Our Case Number: ACP-324126-26

Re: Improvements to Public Realm to Bridge Street and lands to the rear and side of The Grain Store,
John's Street, New Ross, County Wexford.
Bridge Street and John's Street, New Ross, County Wexford

Re: **ACP-324126-26**

**Local Authority Development – Appropriate Assessment Application-
Improvements to Public Realm to Bridge Street and lands to the rear and
side of The Grain Store, John's Street, New Ross, County Wexford.**

Drawing file: Further Information - 02.10.26 / ODKM_19-104-ACP-FI-P-150 Sections A-A & B-B As Proposed.pdf

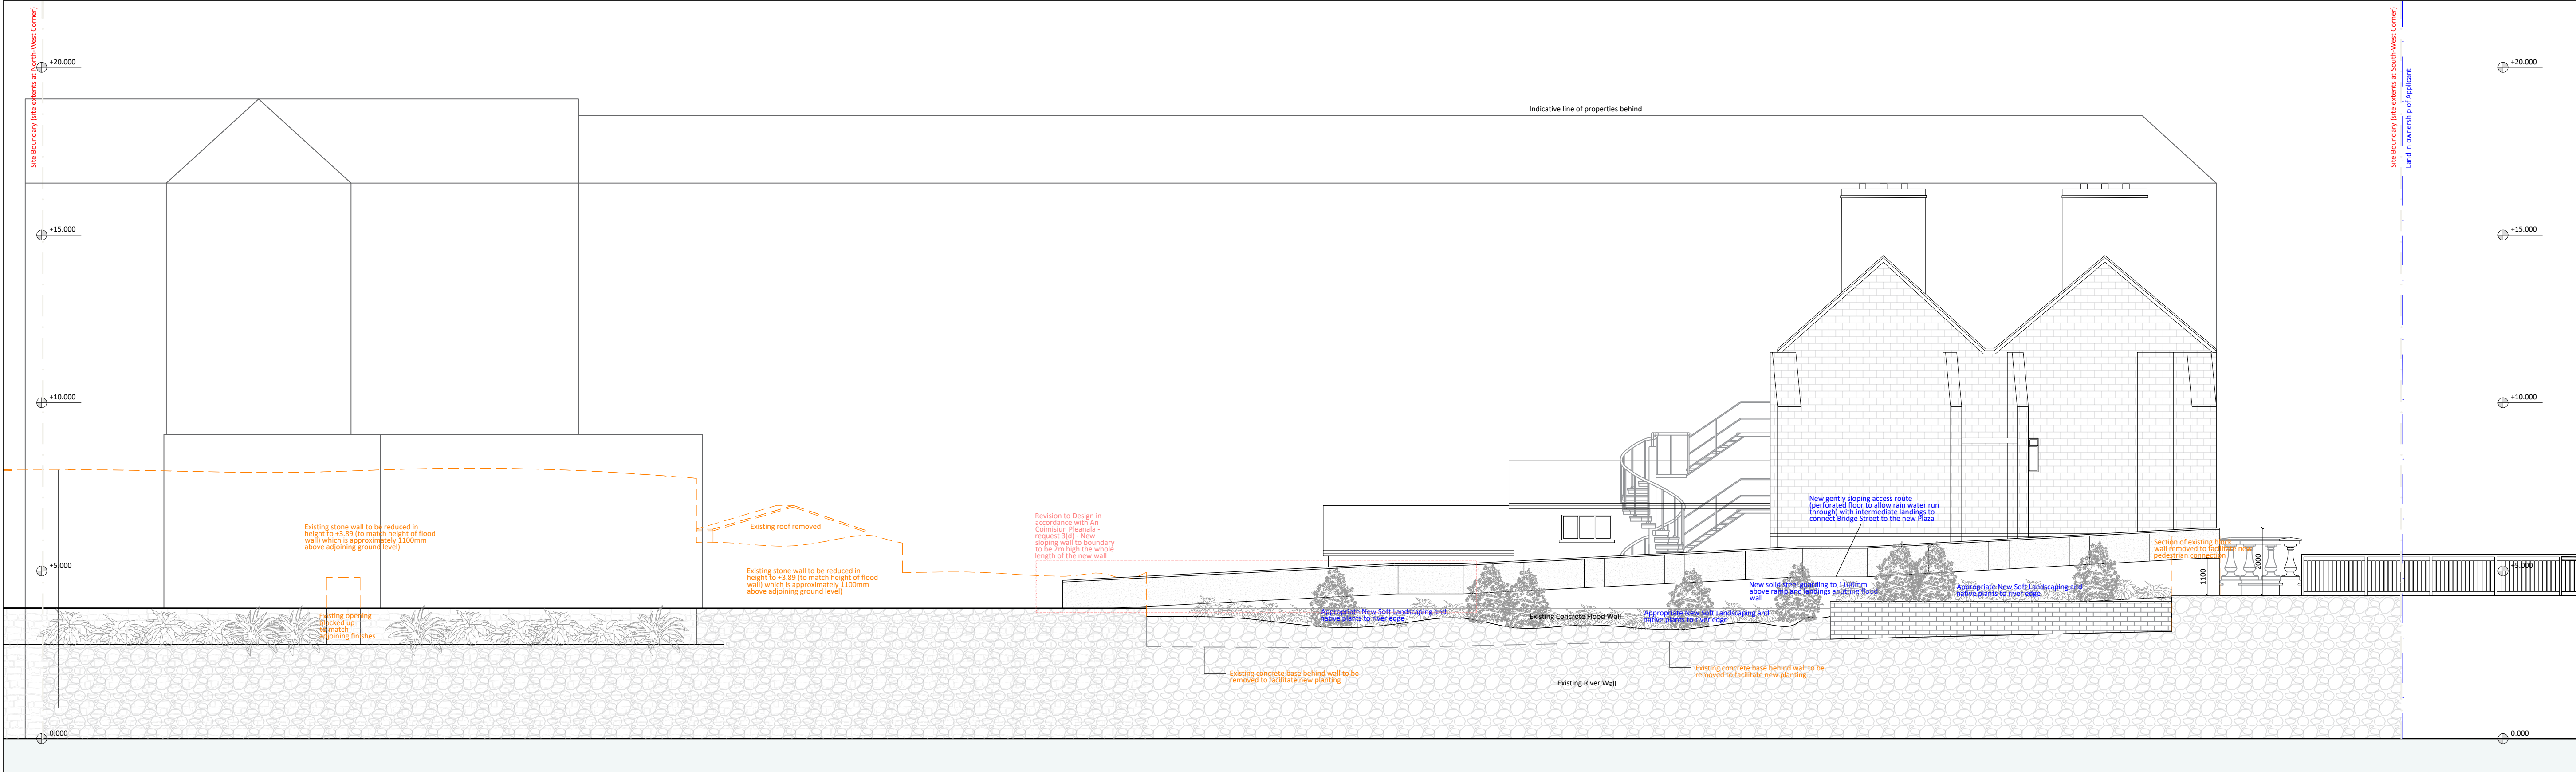
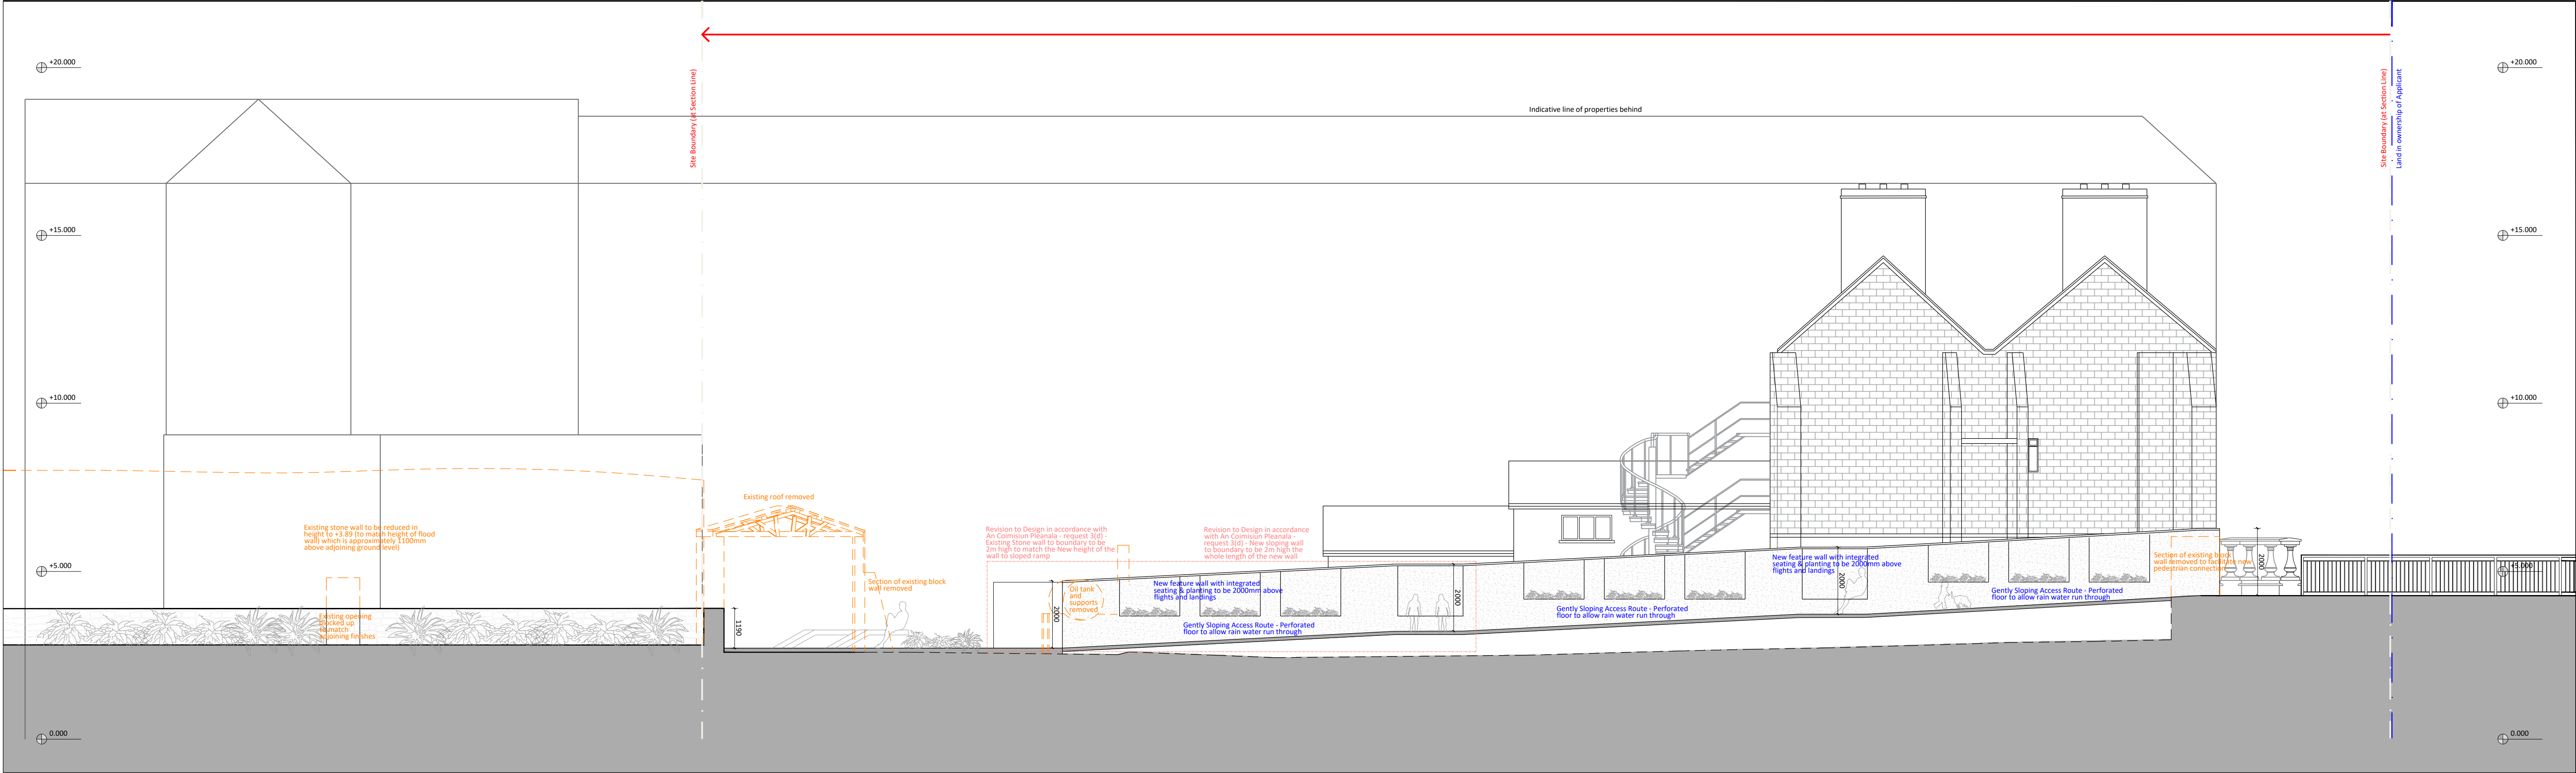
- *Lowering stone wall between the yard area and the river and between proposed plaza and rear of properties on Bridge Street to 1100mm above ground level-* The height of the wall along the new sloping ramp is generally 2m. However, the current proposal to taper the wall to the rear of Rogers Dental to 1100mm can be revised to provide a consistent wall height of 2m on the eastern and northern elevations.
